DOC17/406027-1
MP10-0137 MOD 8

Review of response to submissions for modification application - Huntlee Residential Subdivision – Stage 1 subdivision and works, Branxton (MP10-0137 MOD 8)

Figure 5 Required APZ (PBP 2006)

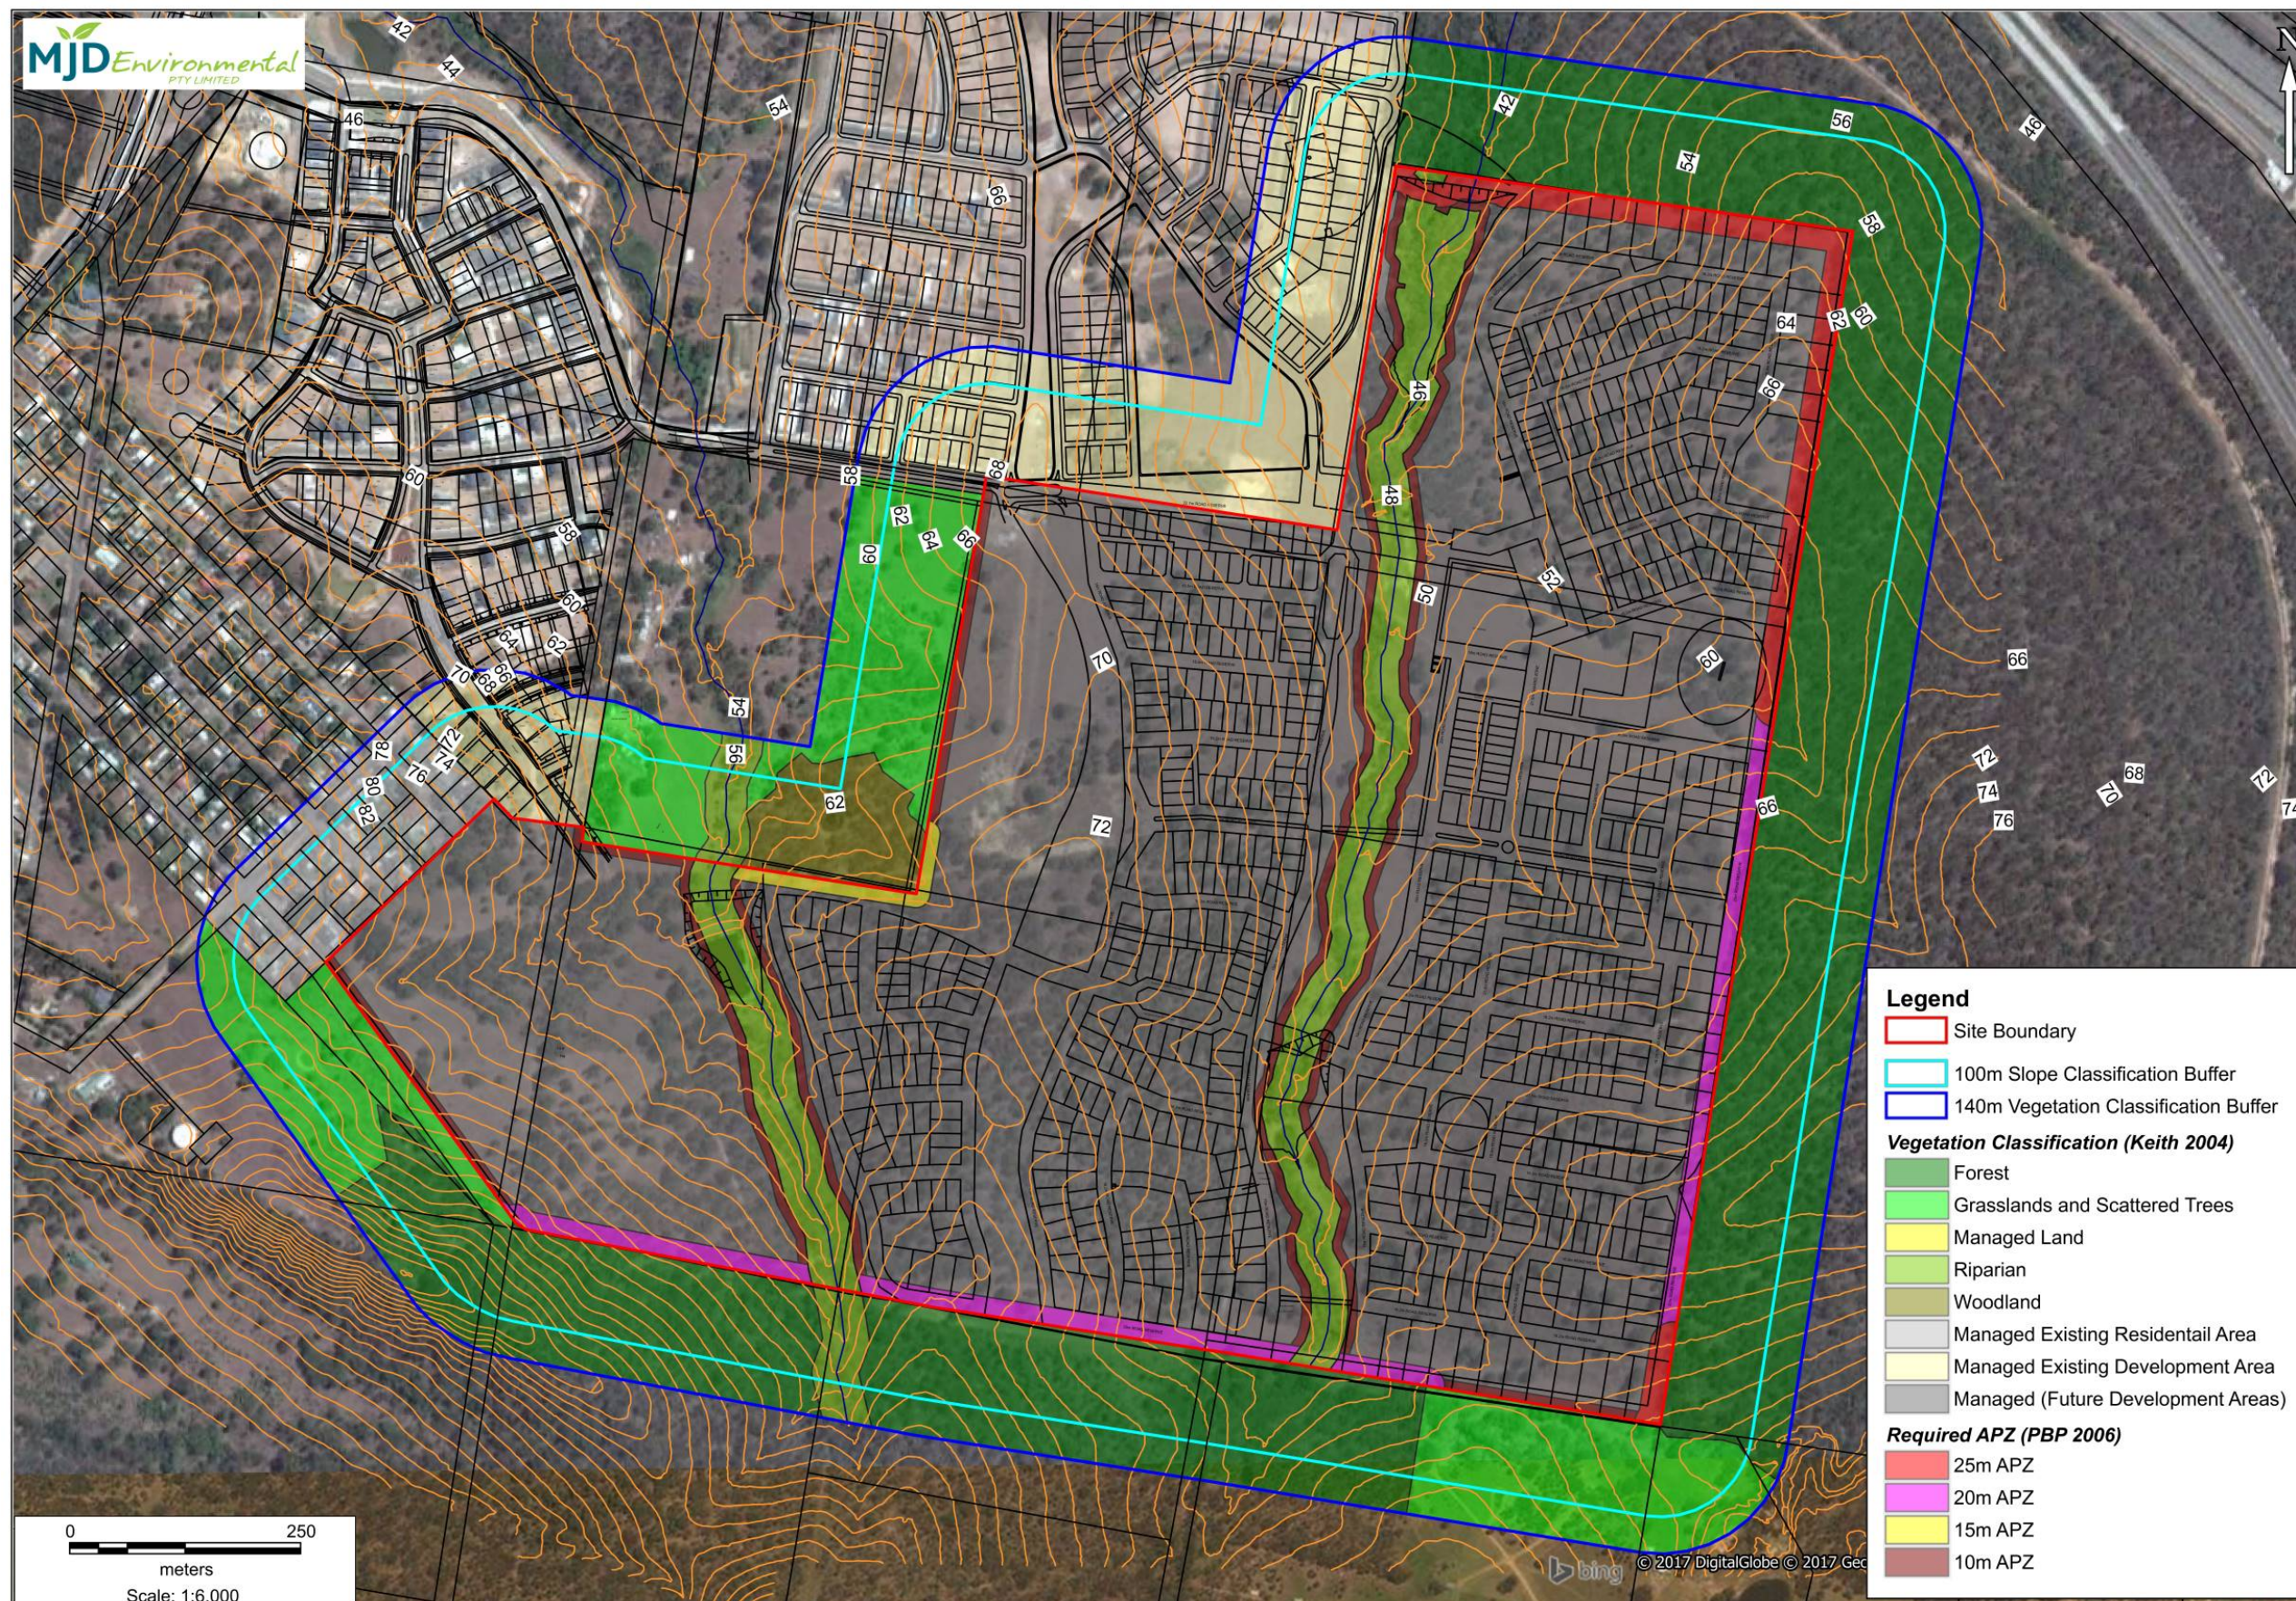
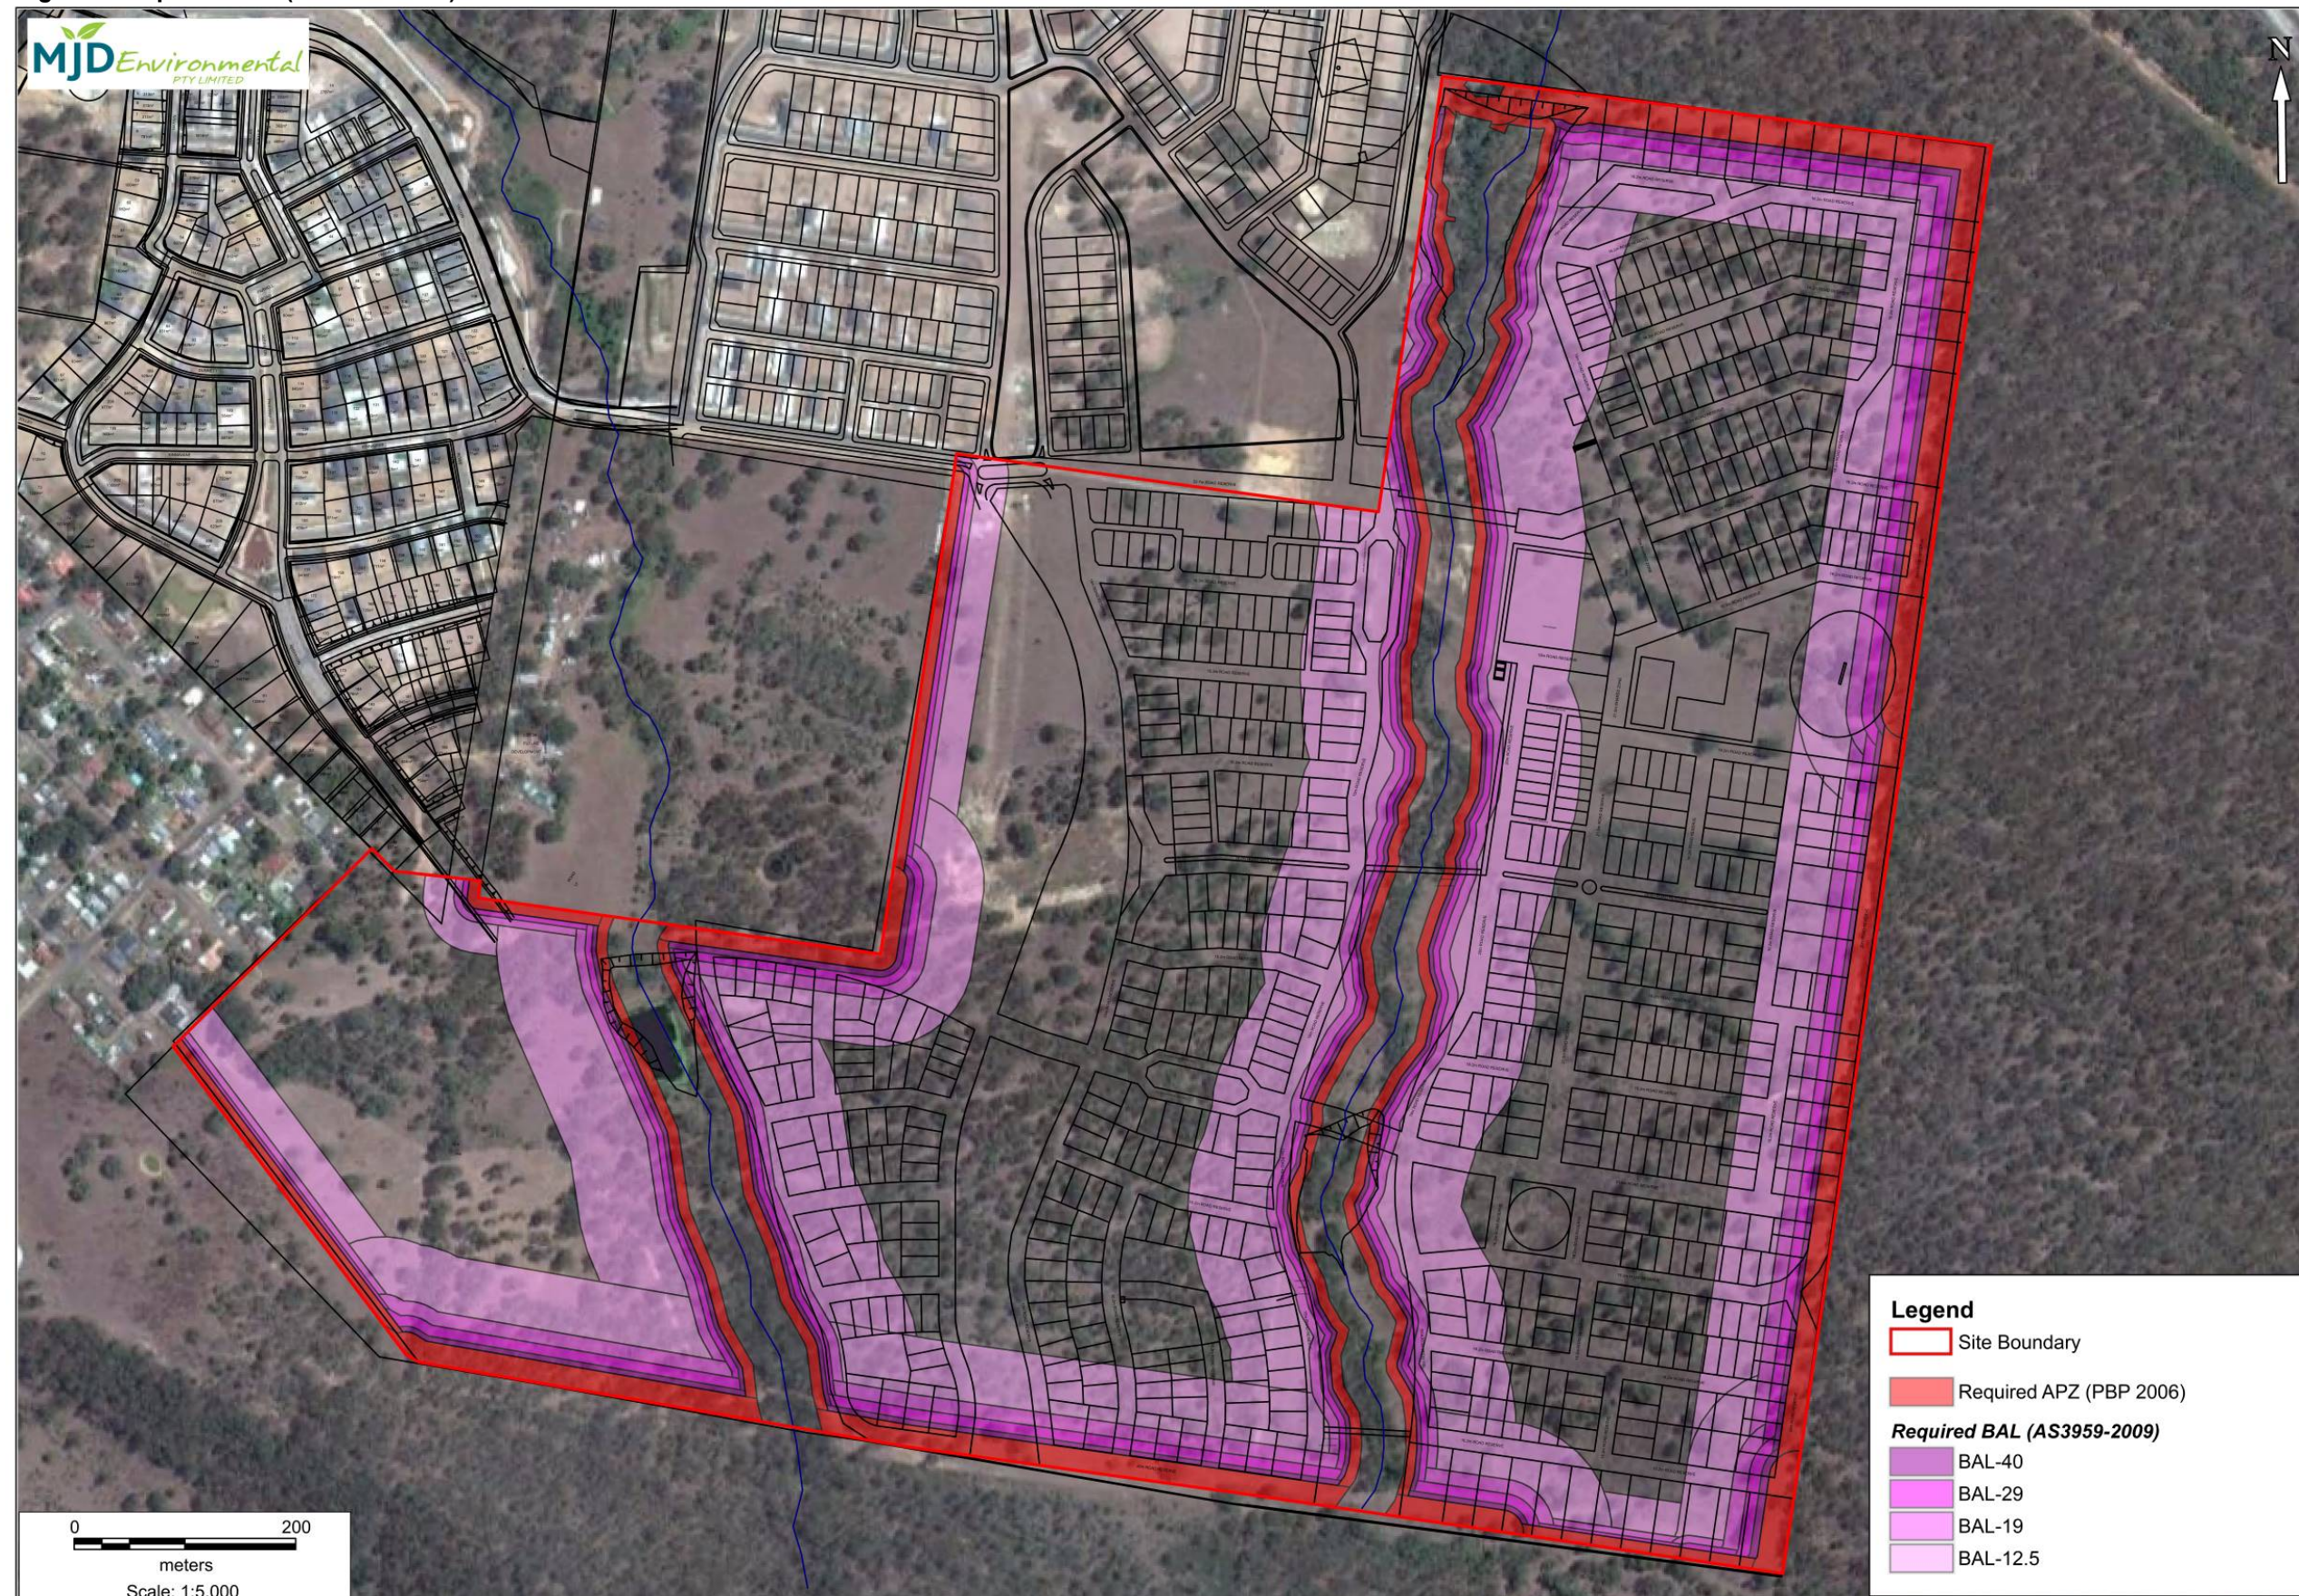
OEH sought clarification that the asset protection zones (APZ) are entirely contained within the development areas outlined in the Bushfire Threat Assessment, Figures 5 and 6 (MJD Environmental, April 2017), and do not encroach on any conservation zones.

After a phone conversation on the 31 August 2017 with OEH, Matt Doherty of MJD Environmental has confirmed in an email that:

- all APZs will be inside the development footprint
- any temporary APZs referred to are also within the development area outlined in the document
- the APZs do not encroach on any areas set aside for conservation.
